Our ref: Fort Street Public School-Mod-2 (SSD-10340-Mod-2)

Subject: Response to Submissions

I refer to the modification report for the Fort Street Public School (SSD-10340-Mod-2) and the Department's correspondence dated 18 January 2023.

1 ELEVATION NORTH  
1:200

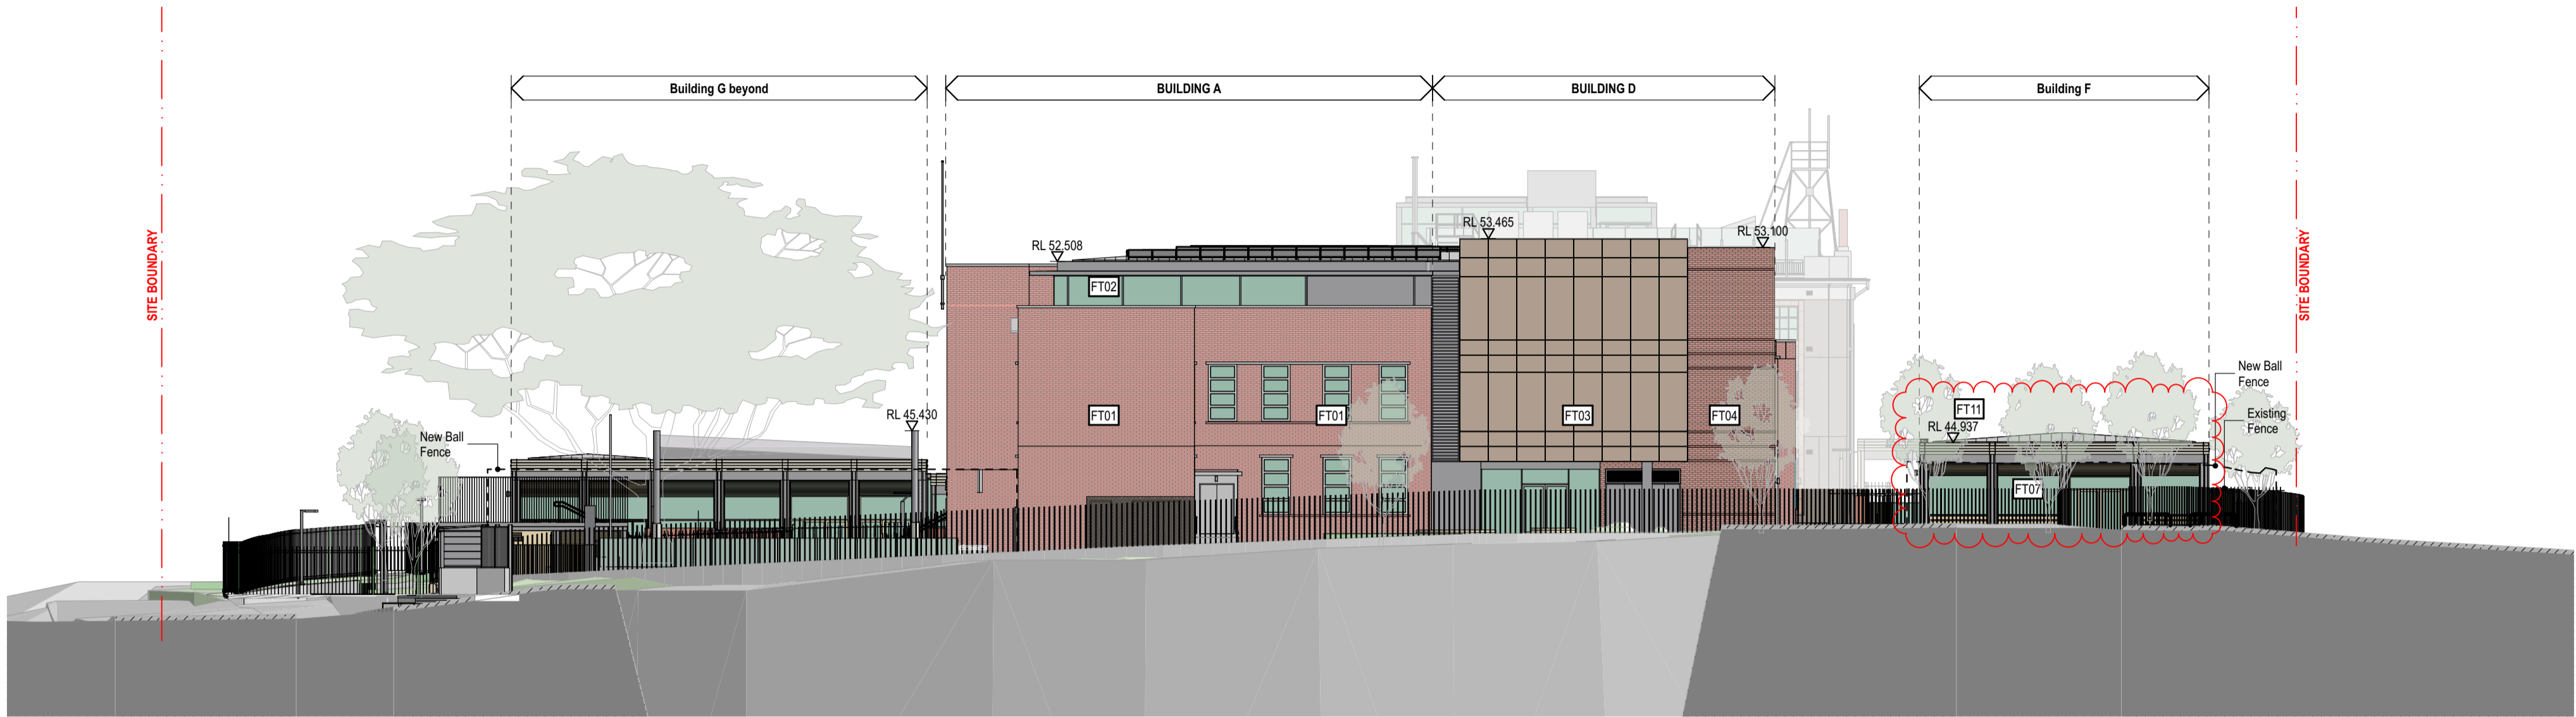
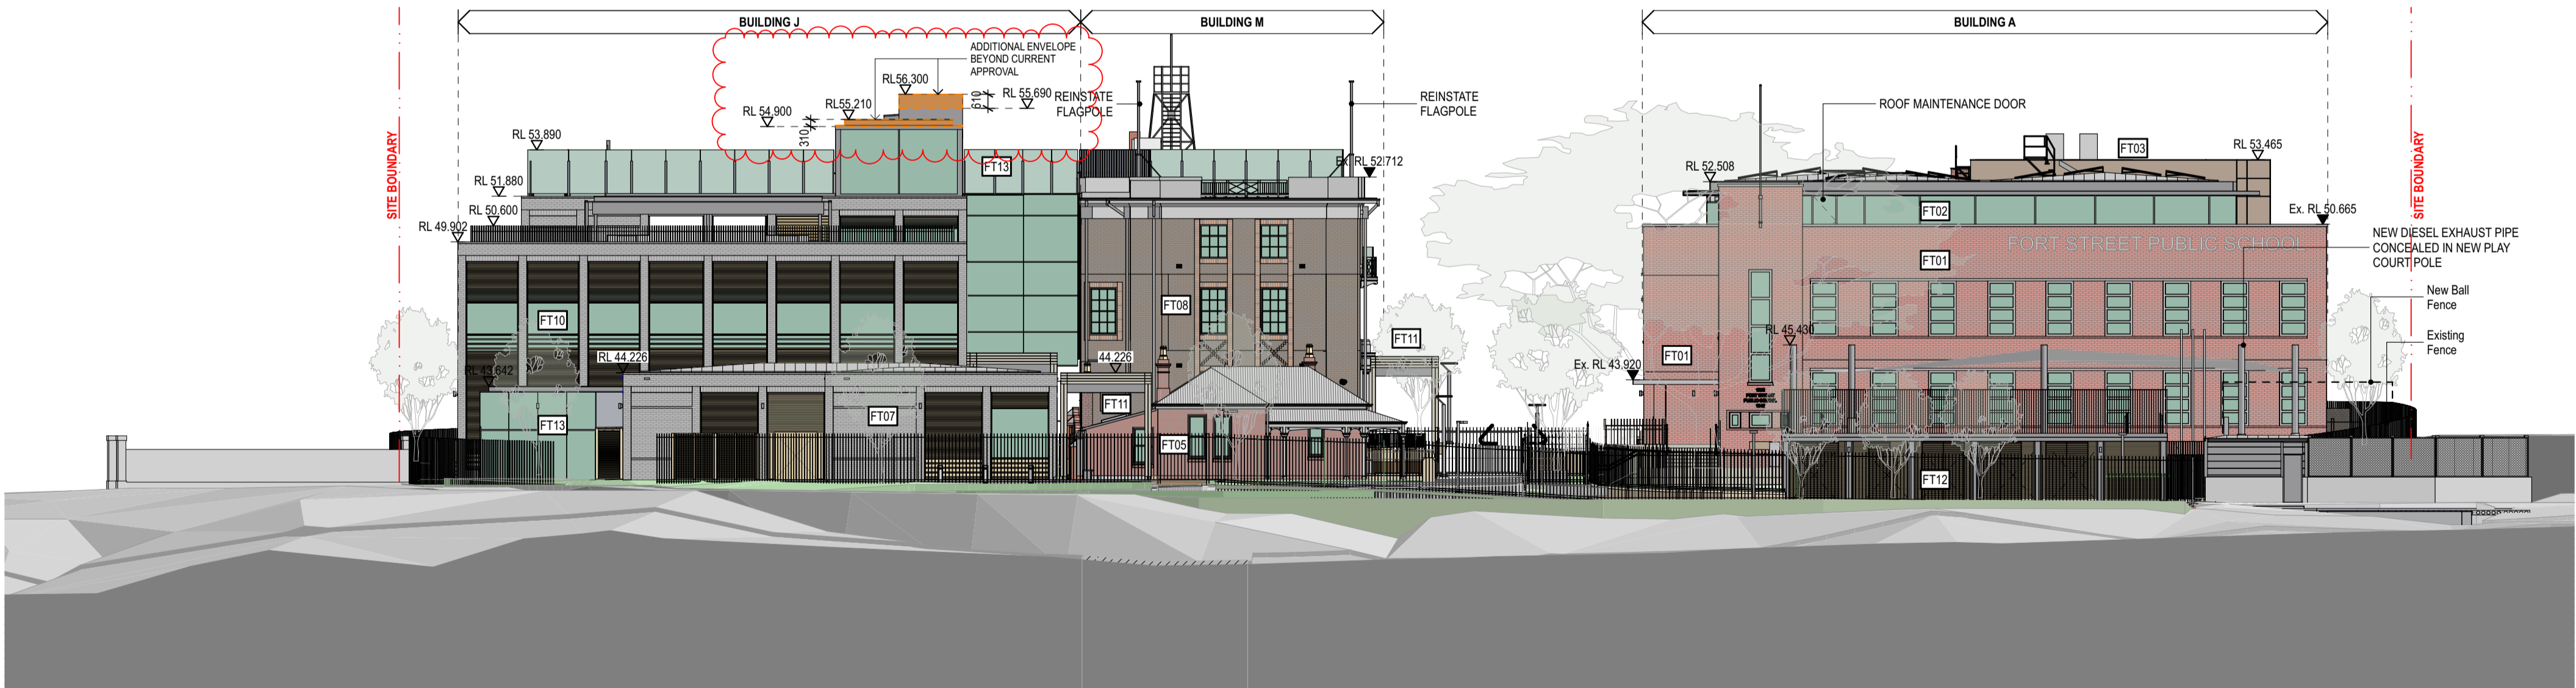
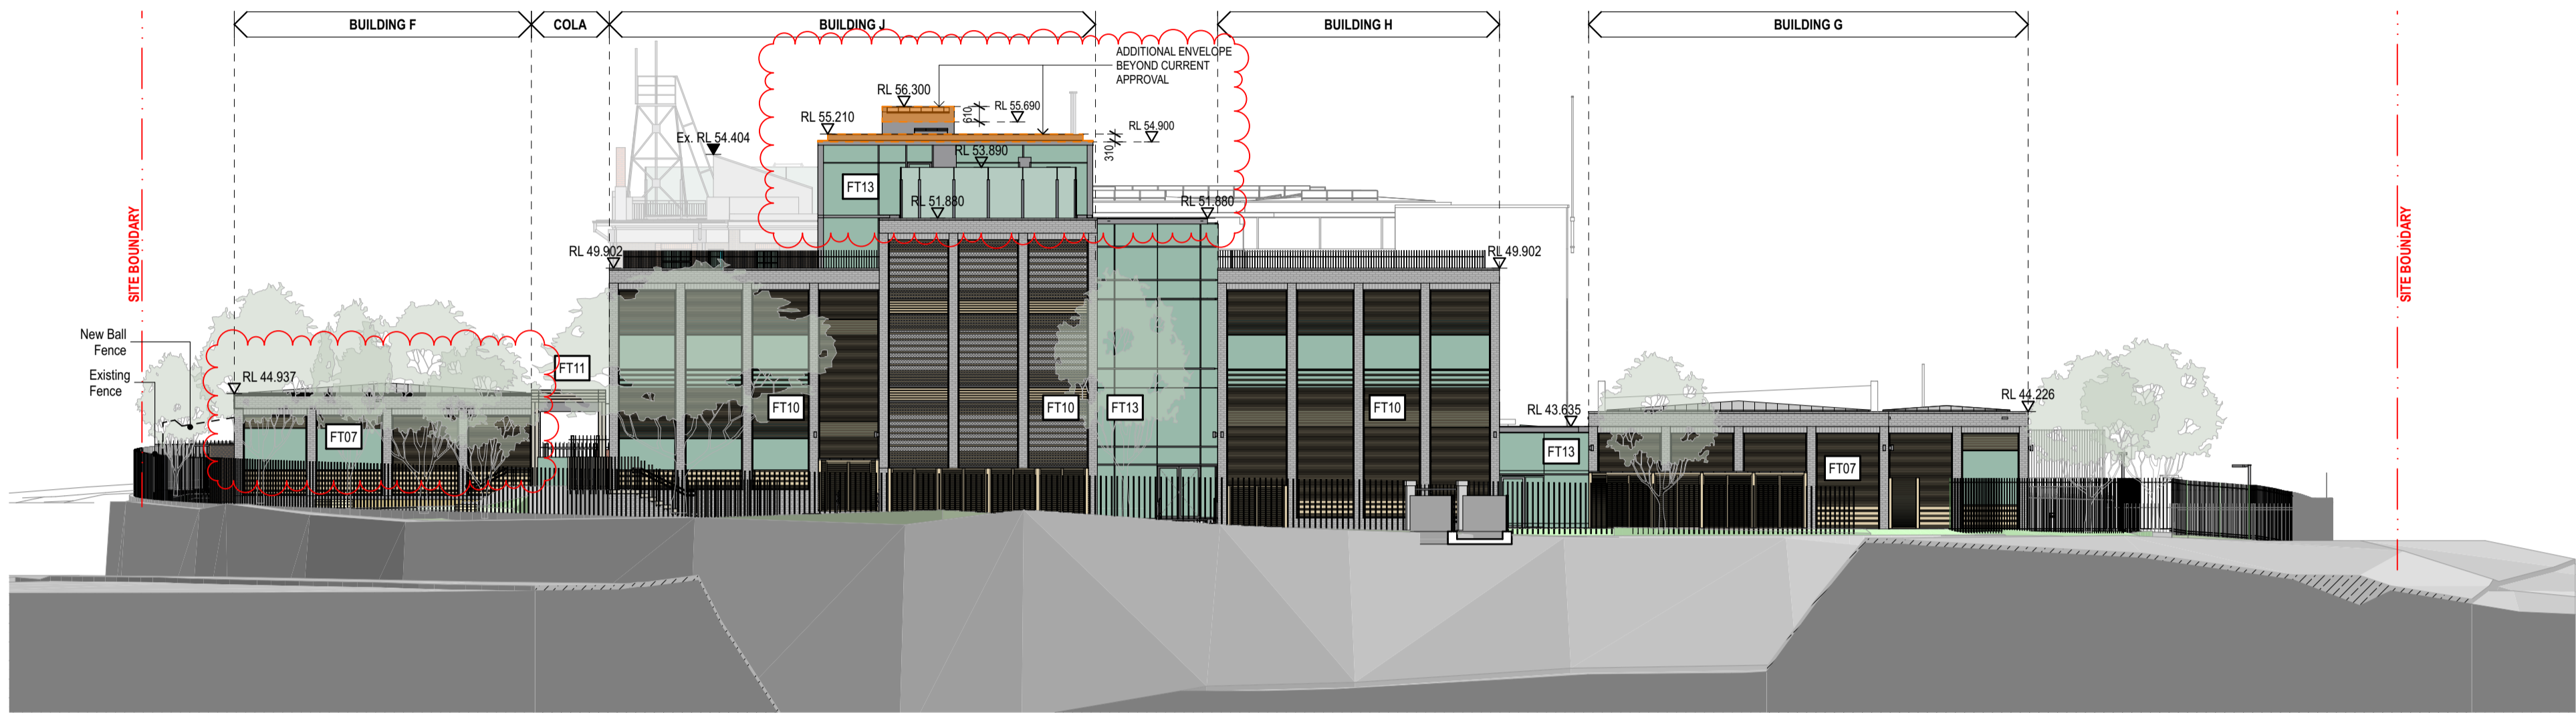
- Clearly identify spandrels on submitted plans.
- Confirm if the changes to the finished ground levels require updates to the approved landscape plans.
- Provide shadow diagrams to confirm any impacts of the additional height.
